Application for a non-material amendment following a grant of planning permission.

PART TWO STOREY, PART SINGLE STOREY SIDE EXTENSION AND SINGLE STOREY FRONT EXTENSION.

6921/APP/2019/2868

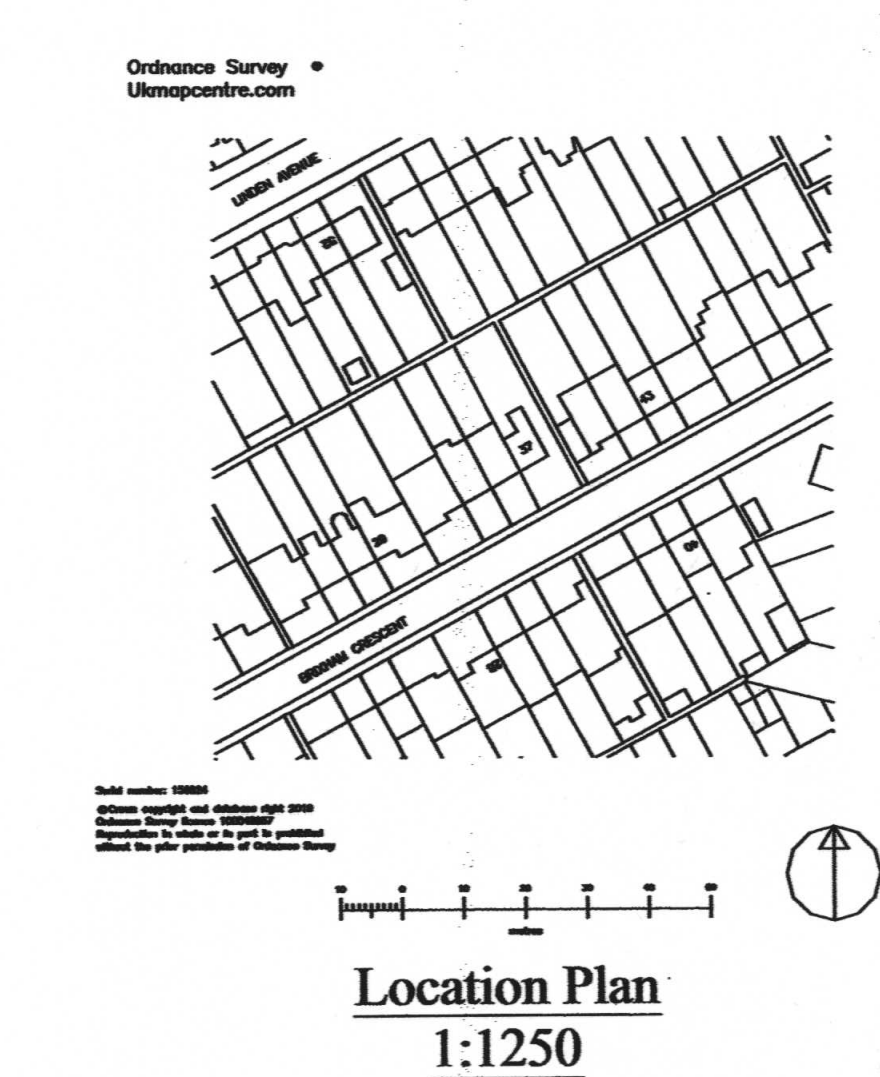
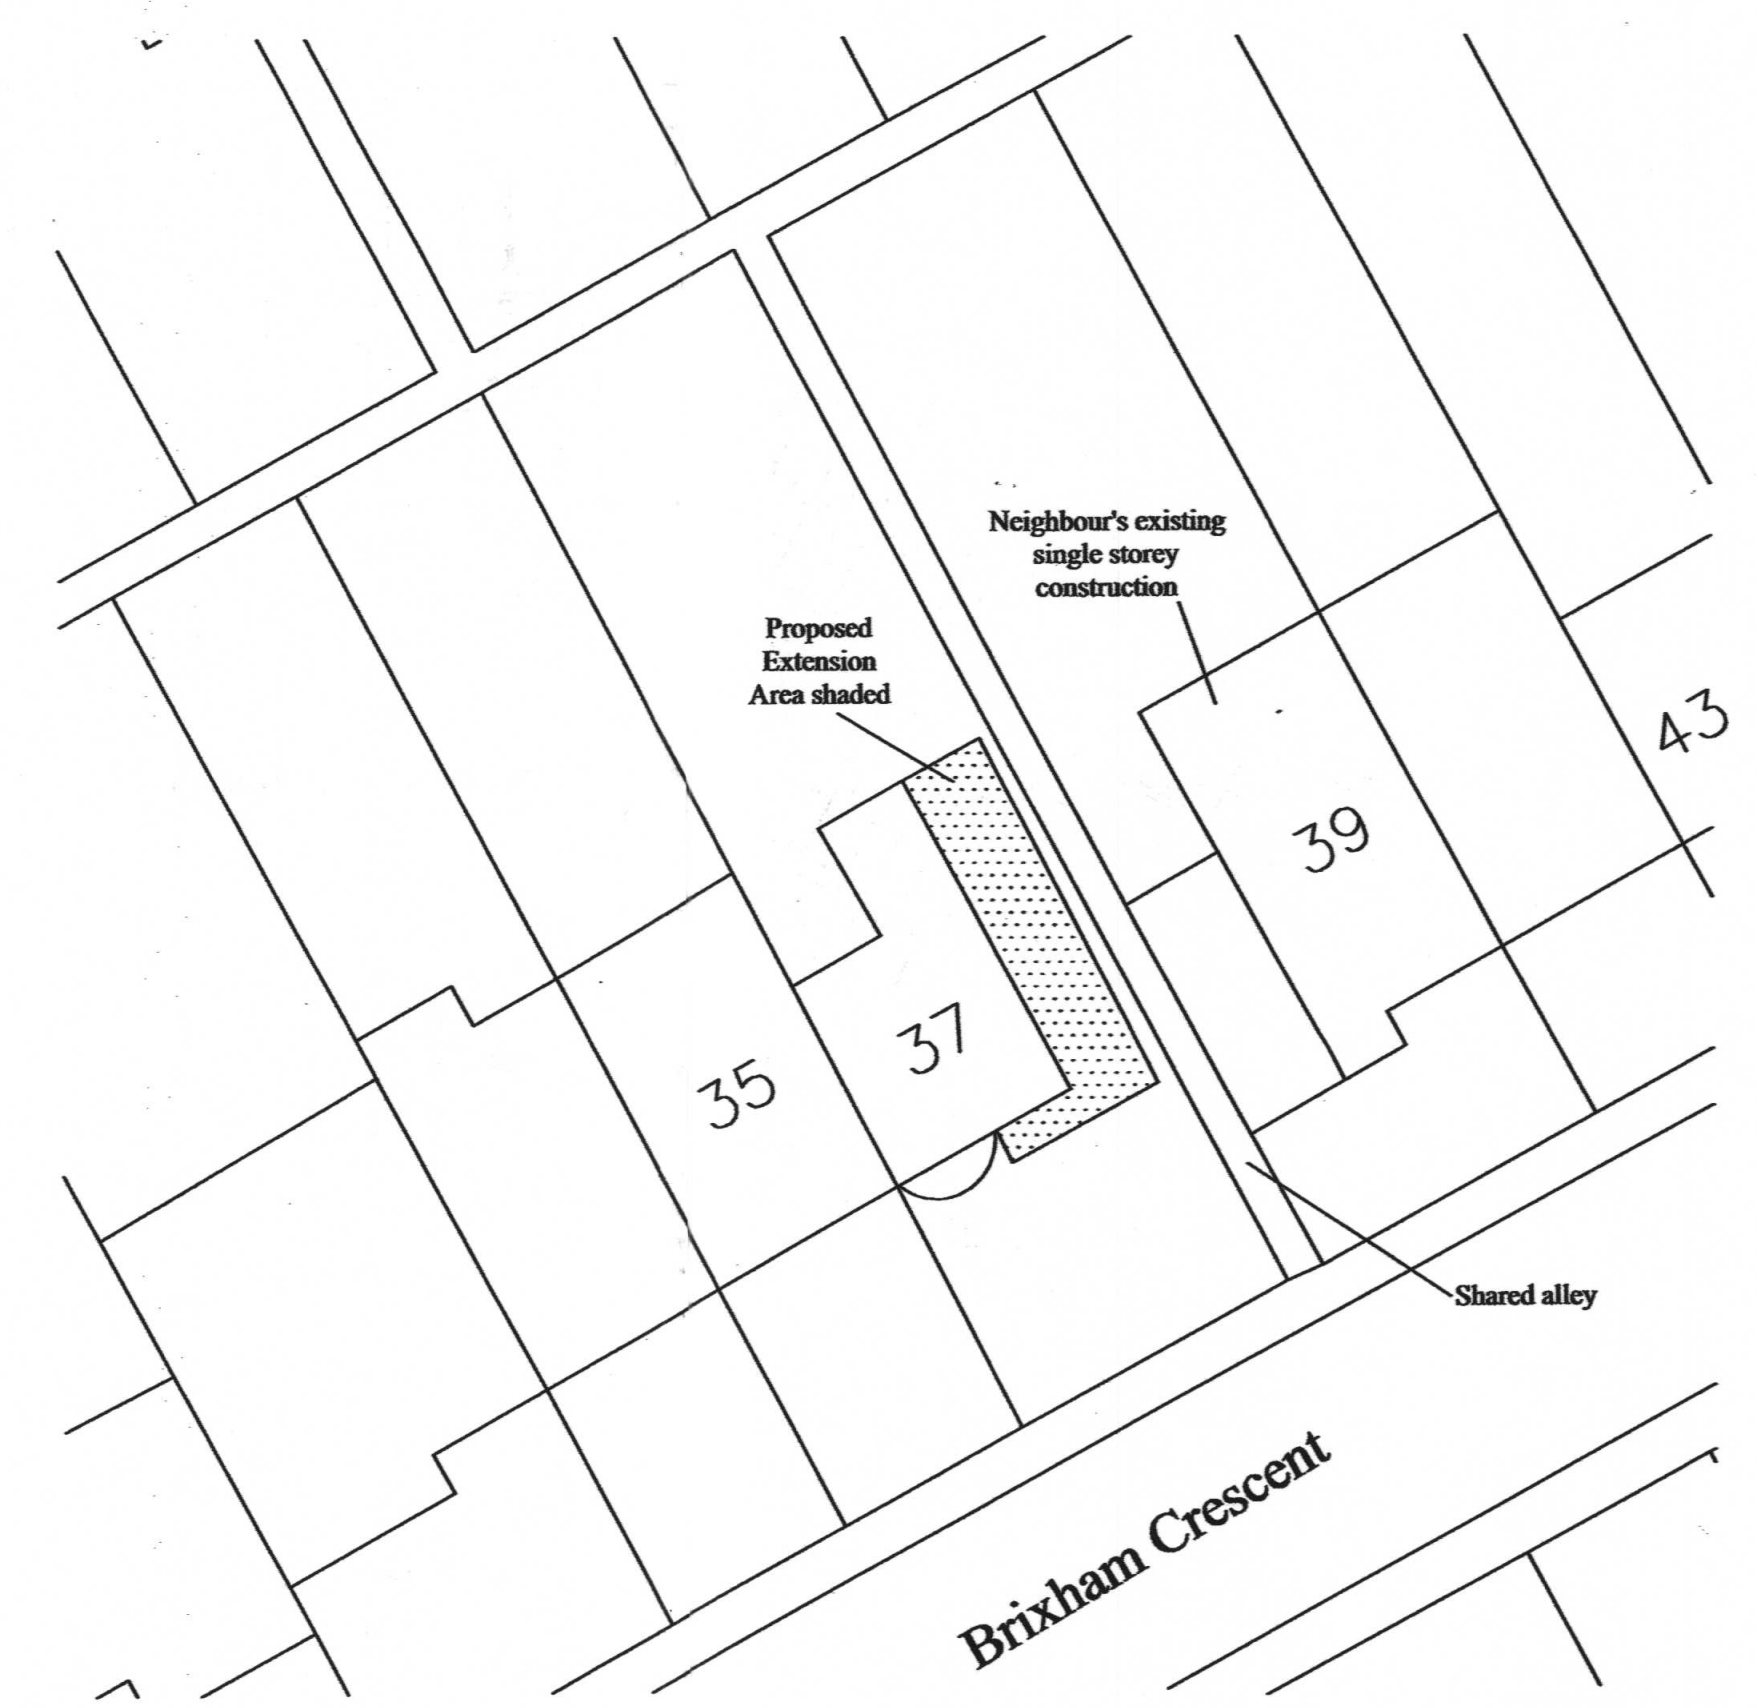
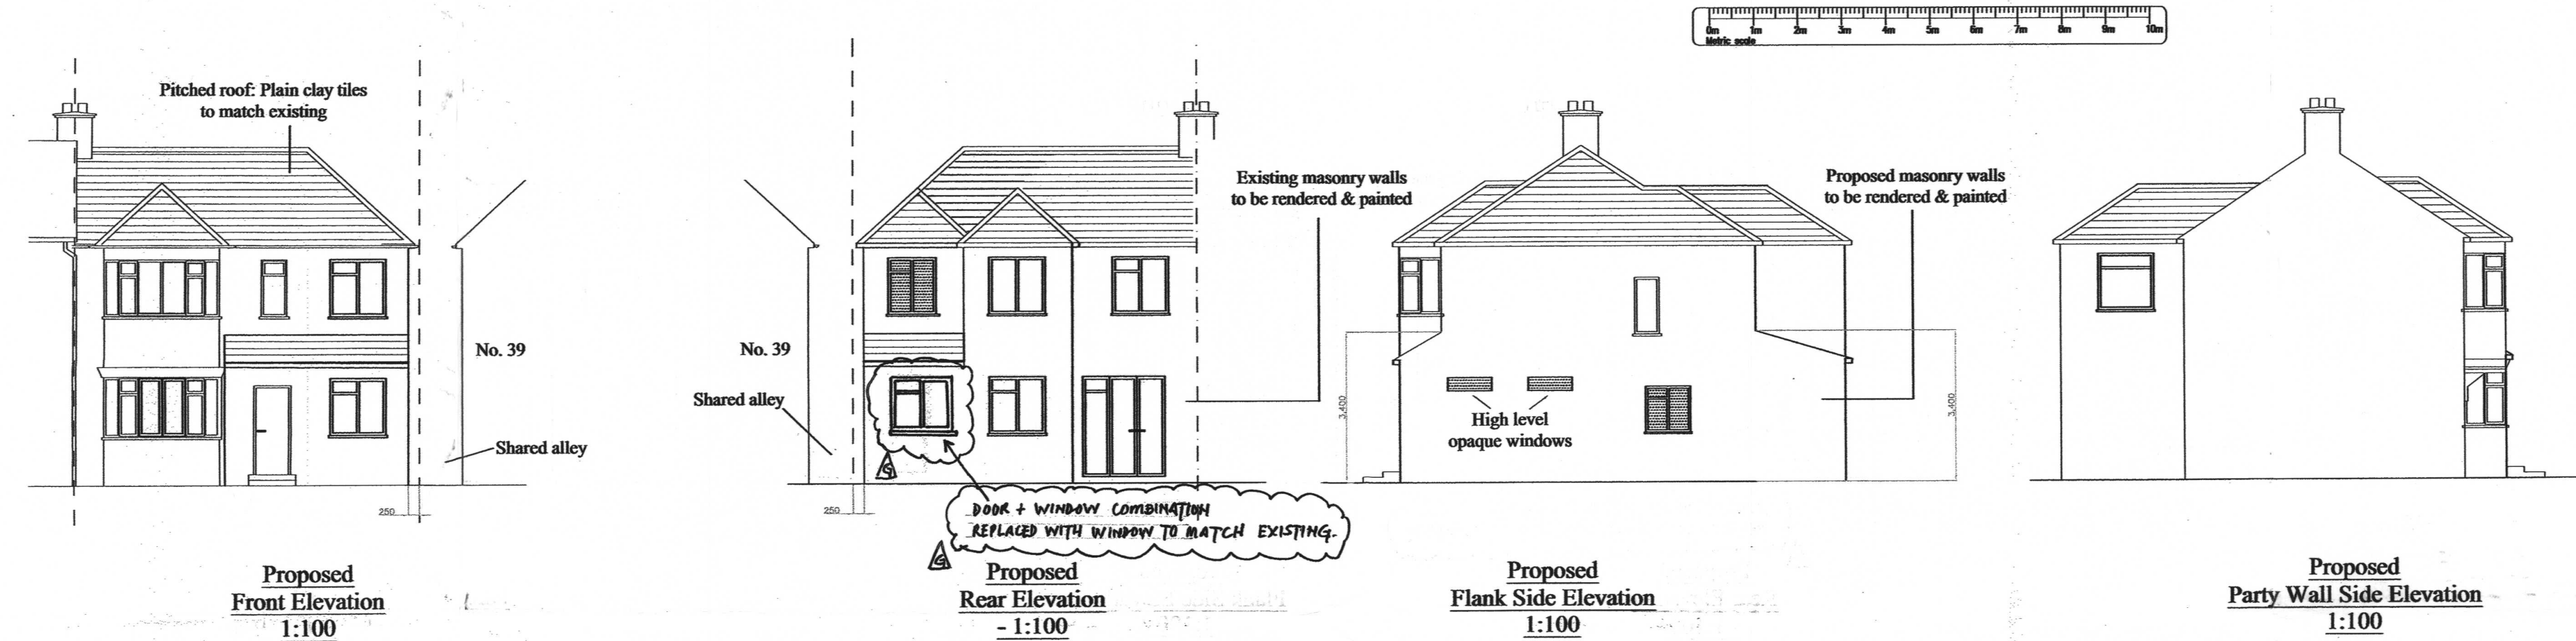
WE ARE SEEKING TO REMOVE THE DOOR THAT ACCESSES THE GARDEN DIRECTLY FROM THE KITCHEN AND REPLACE IT WITH A WINDOW TO MATCH AN EXISTING ADJACENT WINDOW IN THE SAME ROOM.

THE DOOR WILL BE REMOVED IN ORDER TO OPTIMISE THE PROPOSED INTERIOR LAYOUT AND ALSO INCREASE SECURITY. THE VELUX (OR SIMILAR) ROOF WINDOW WILL SUBSTANTIALLY INCREASE NATURAL LIGHT IN THIS NORTH FACING SPACE.

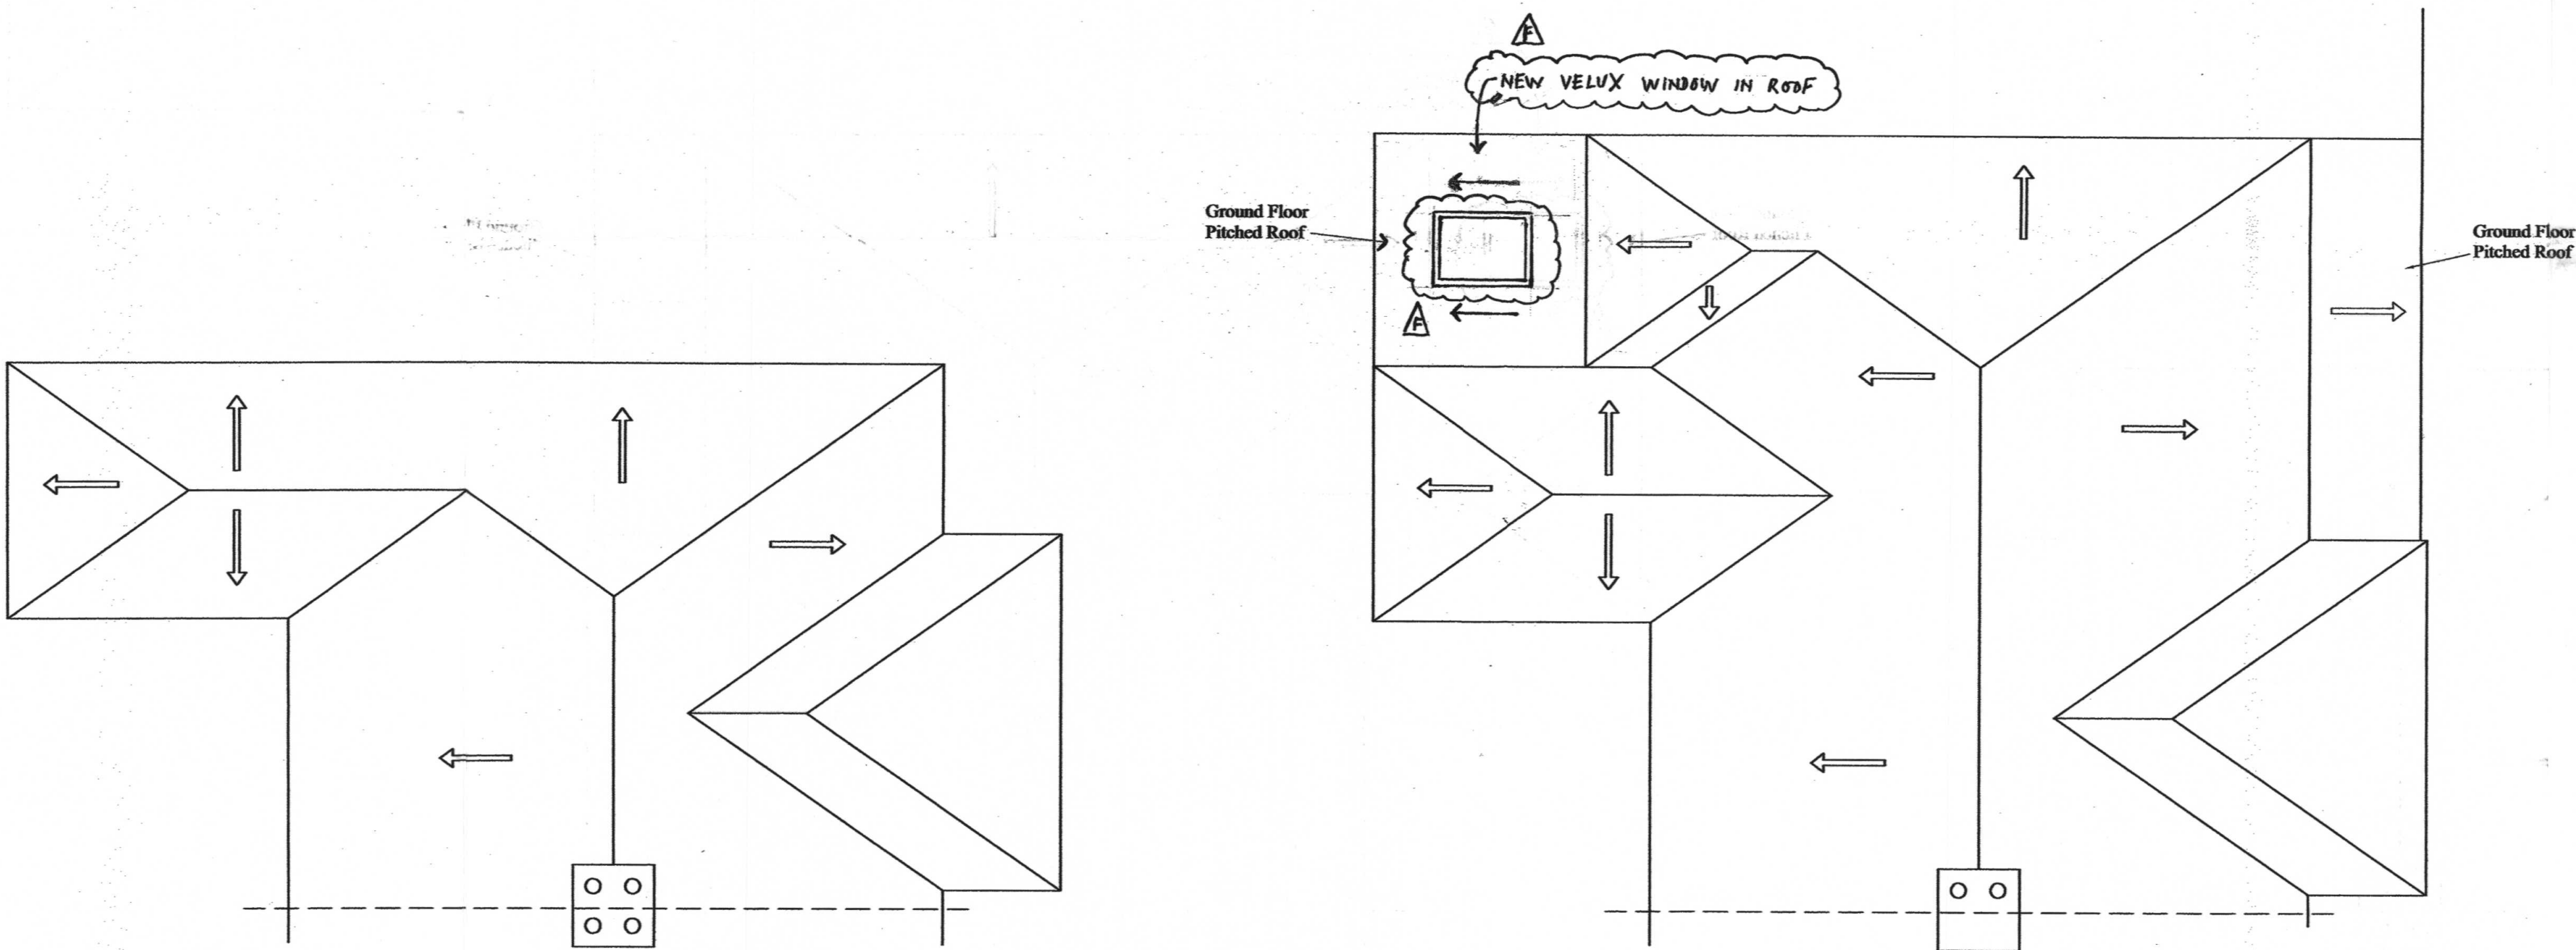
WE ALSO PROPOSE TO ADD A MODEST VELUX (OR SIMILAR) ROOF WINDOW TO THE SINGLE STOREY PITCHED ROOF AREA OF THE EXTENSION.
